**From:** [Toni Berkshire](#)  
**To:** [Jeremiah Cromie](#)  
**Subject:** RE: SE-21-00031 Mundy - Notice of Application  
**Date:** Friday, February 4, 2022 10:00:24 AM

In response to SE-21-00031:

MUNDY/HILL PROPERTIES
 BILL MUNDY
 EXISTING CONDITIONS

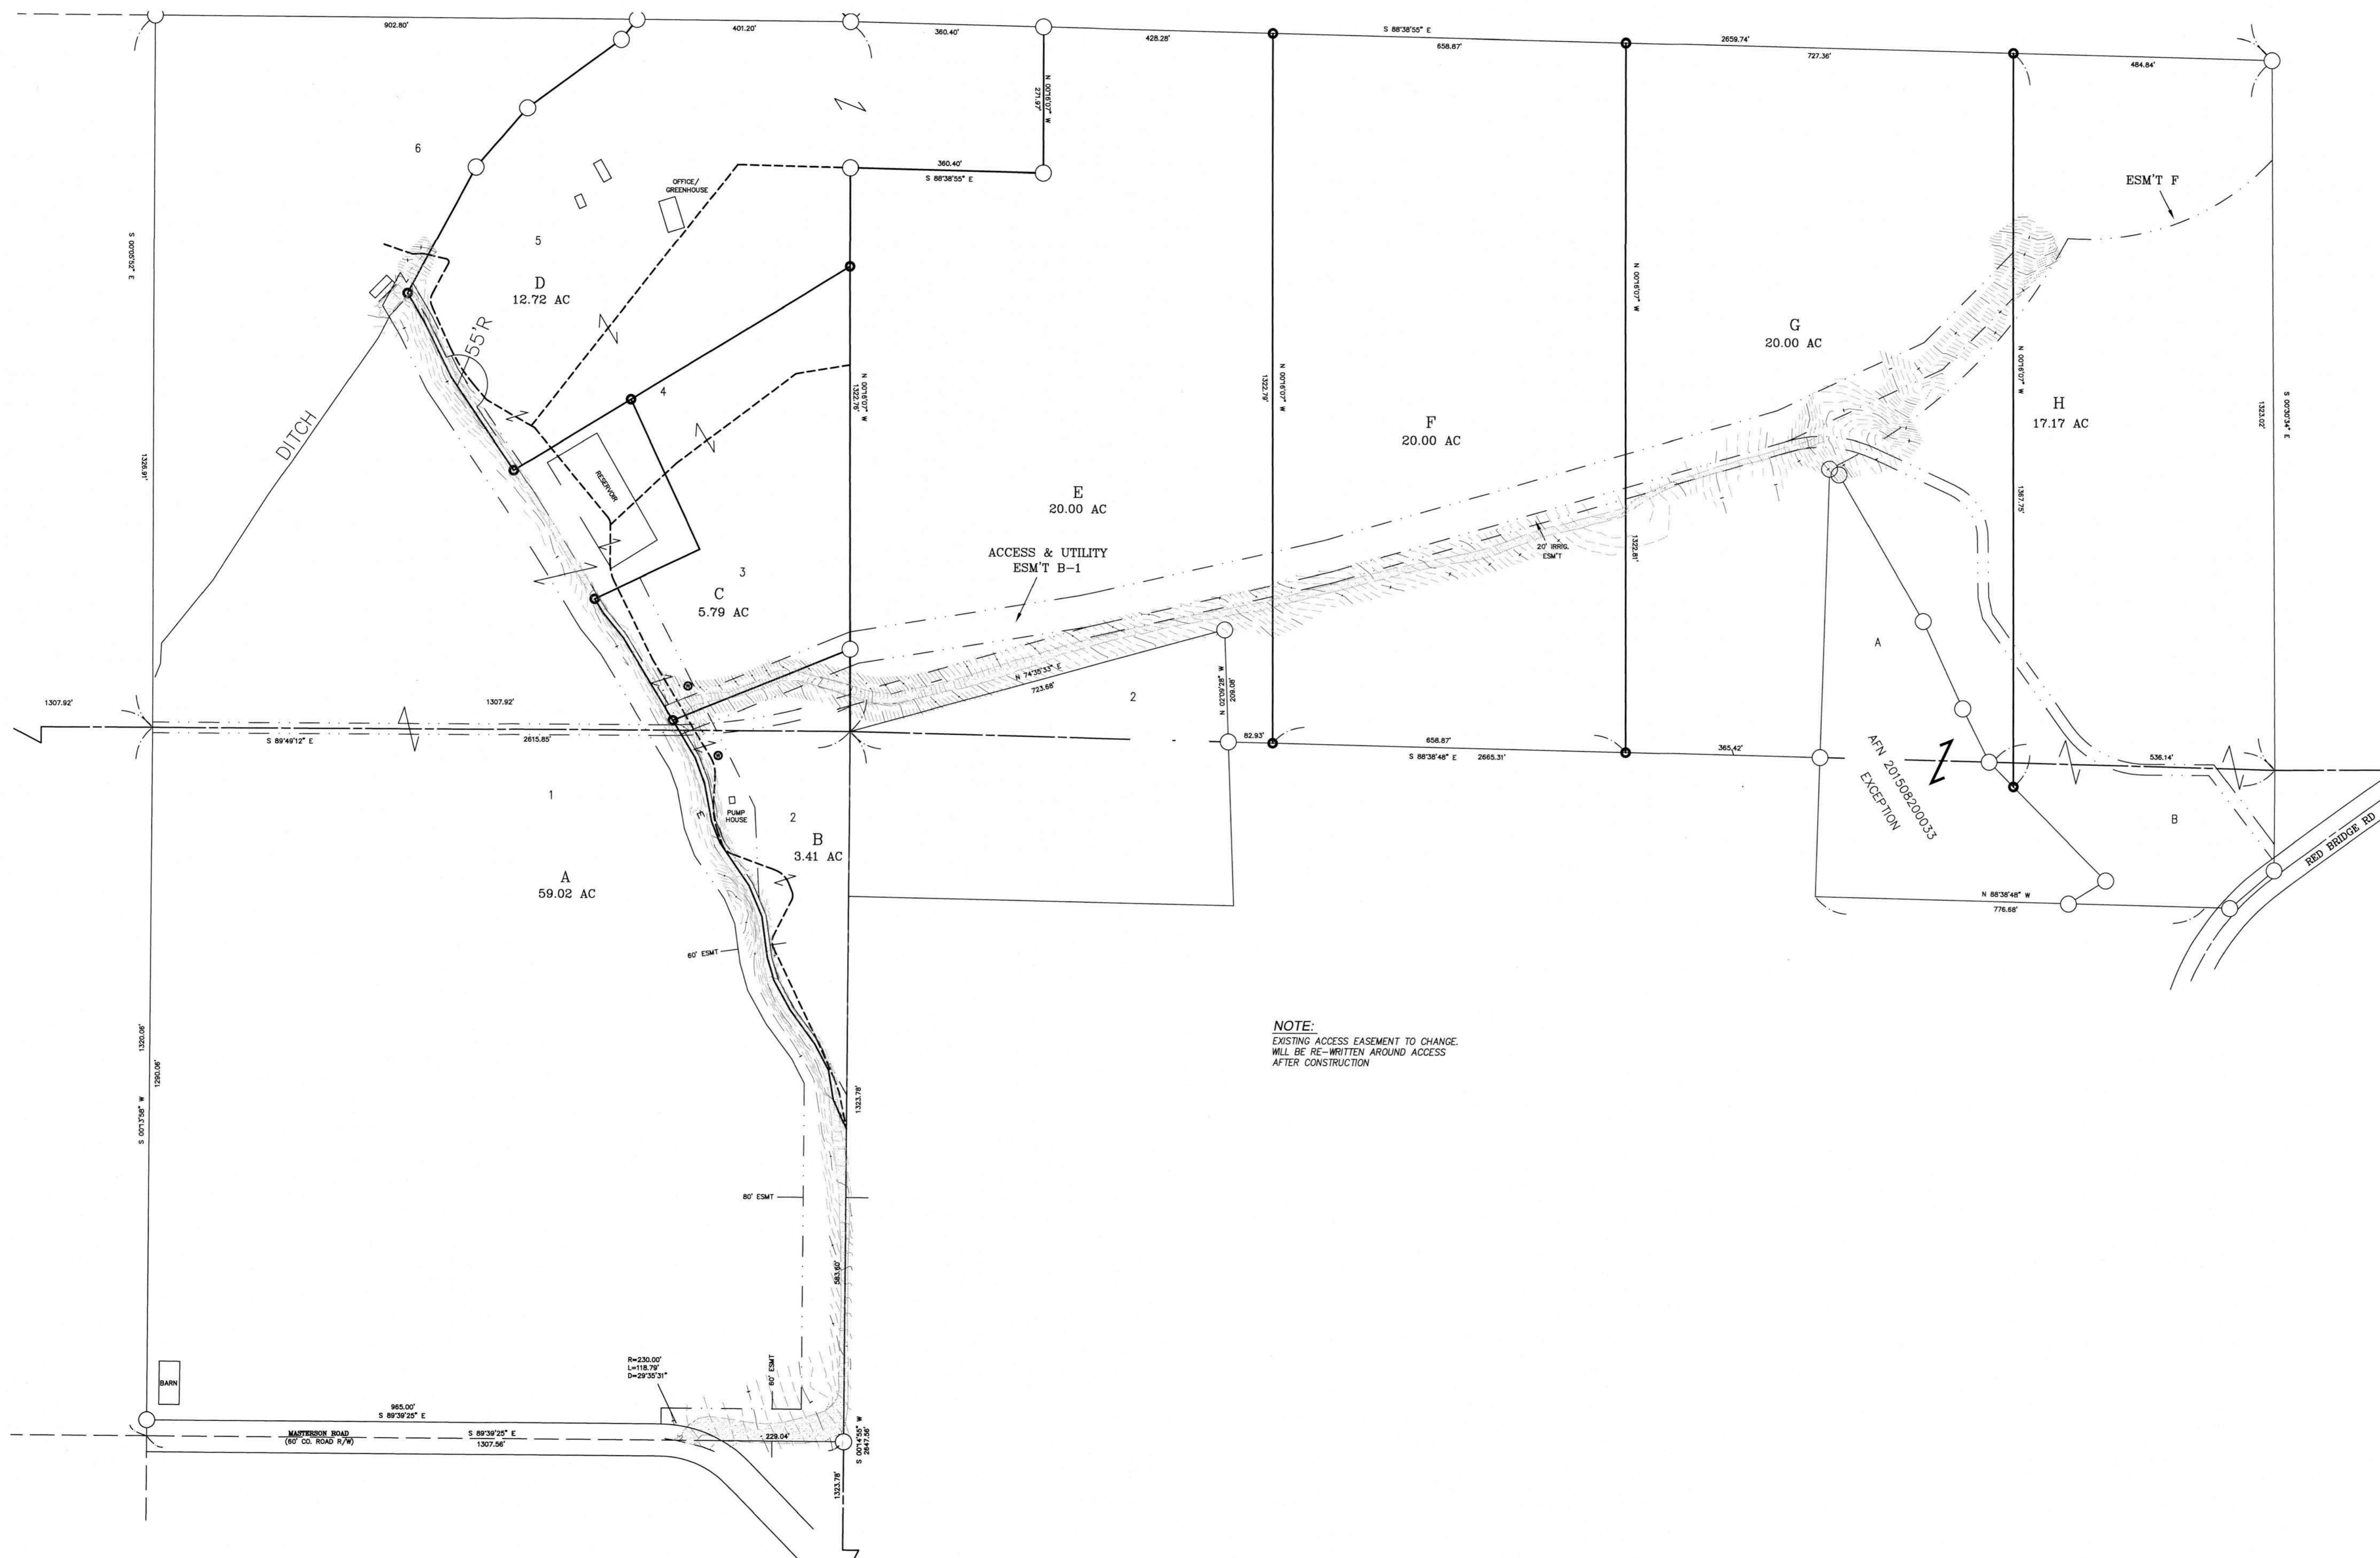
Code Enforcement has an open case for the removal of a drainage ditch and unpermitted fill brought to the parcel which we were advised of in September 2021. Evidence of past flooding along the southern driveway of parcel 504636 and the removal of a drainage ditch has been provided to Code Enforcement. The removal of the drainage ditch altered the existing flow of storm water, streams or other historical flow, a violation of Kittitas County Code (KCC 14.05.120). Mr. Mundy was advised to permanently restore the drainage ditch or install a swale farther north in the driveway to alleviate potential flooding and divert the stormwater into the cropland as a temporary measure to prevent flooding until this private road project could be approved and completed. Mr. Mundy chose to create the swale. During the course of the case, Mr. Mundy has acknowledged that he removed the drainage ditch and that it was initially installed when the driveway was created to prevent run-off from entering the cropland and control cropland erosion.

Comparing my knowledge of this Code Enforcement case with Mr. Mundy's SEPA Environmental Checklist, I have concerns that the above information is not being provided. Particularly Question B.3.c.3 which states that historical flow has led to the field and Question B.3.d which states the road system has been designed to not change the historical drainage path for runoff. The historical drainage path has been a drainage ditch which Mr. Mundy removed from the parcel in 2021. [REDACTED]
